The London Resort Development Consent Order

Appendix 11.5 – Statutory consultee responses to the PEIR

Appendix 11.5 Statutory Consultee Responses to the Preliminary Environmental Information Report (Relevant to Landscape and Visual Chapter 11)

Figure 11.6: Local Landscape Character Areas

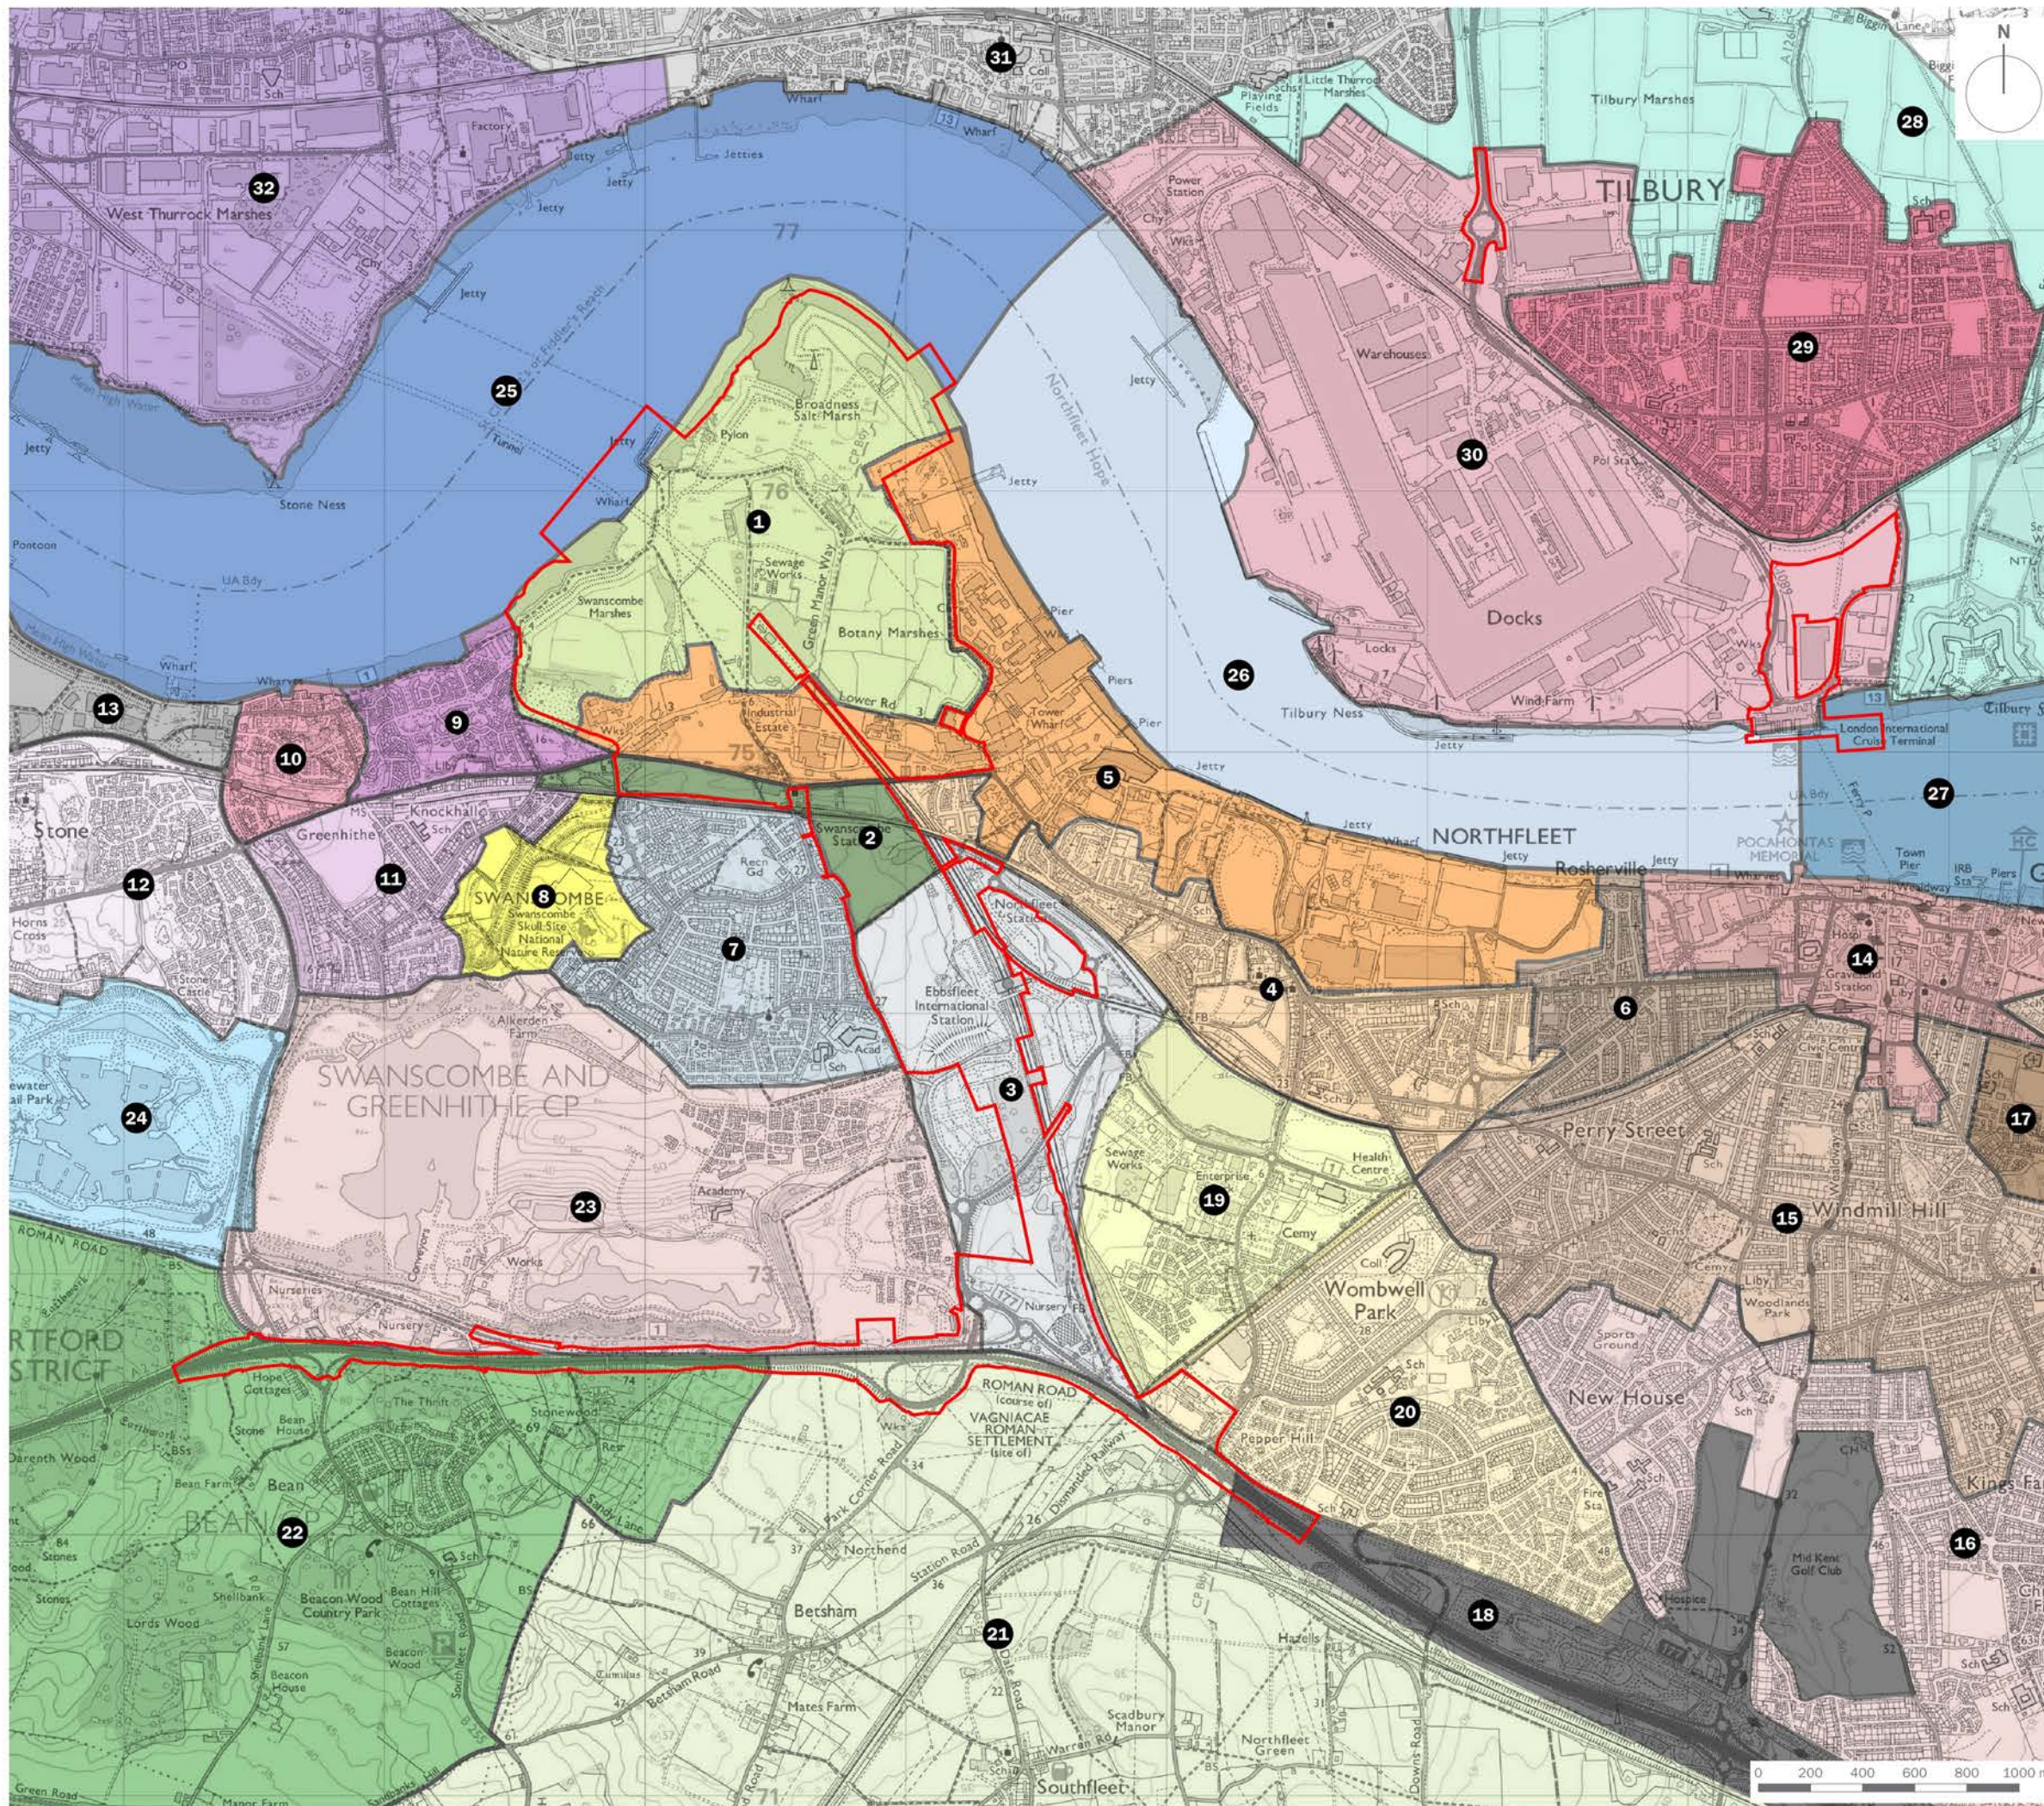
7.3	Section 11.41 of the PEIR Chapter 11 – Landscape suggests that for the impact assessment the local landscape character assessments will be used rather than the National Character Assessments (NCAs). It may be appropriate to refer to the relevant NCAs across the development boundary as these provide helpful guidance on positive measures that can be implemented to restore or enhance the character area within the Statements of Environmental Opportunity. The project is committed to delivering biodiversity net gain but environmental net gain would be a more holistic approach to sustainable development.	The NCAs are referred to within the Landscape and Visual Baseline (Appendix 11.1; document reference 6.2.11.1)).

7.4	As mentioned in our response to the 2020 EIA Scoping Opinion, the environmental impact assessment should include a full assessment of the potential impacts of the development on local landscape character using landscape assessment methodologies. We encourage the use of Landscape Character Assessment (LCA), based on the good practice guidelines produced jointly by the Landscape Institute and Institute of Environmental Assessment in 2013. LCA provides a sound basis for guiding, informing and understanding the ability of any location to accommodate change and to make positive proposals for conserving, enhancing or regenerating character, as detailed proposals are developed.	An assessment on landscape character is provided within Appendices 11.2 and 11.3 (document references 6.2.11.2 and 6.2.11.3).
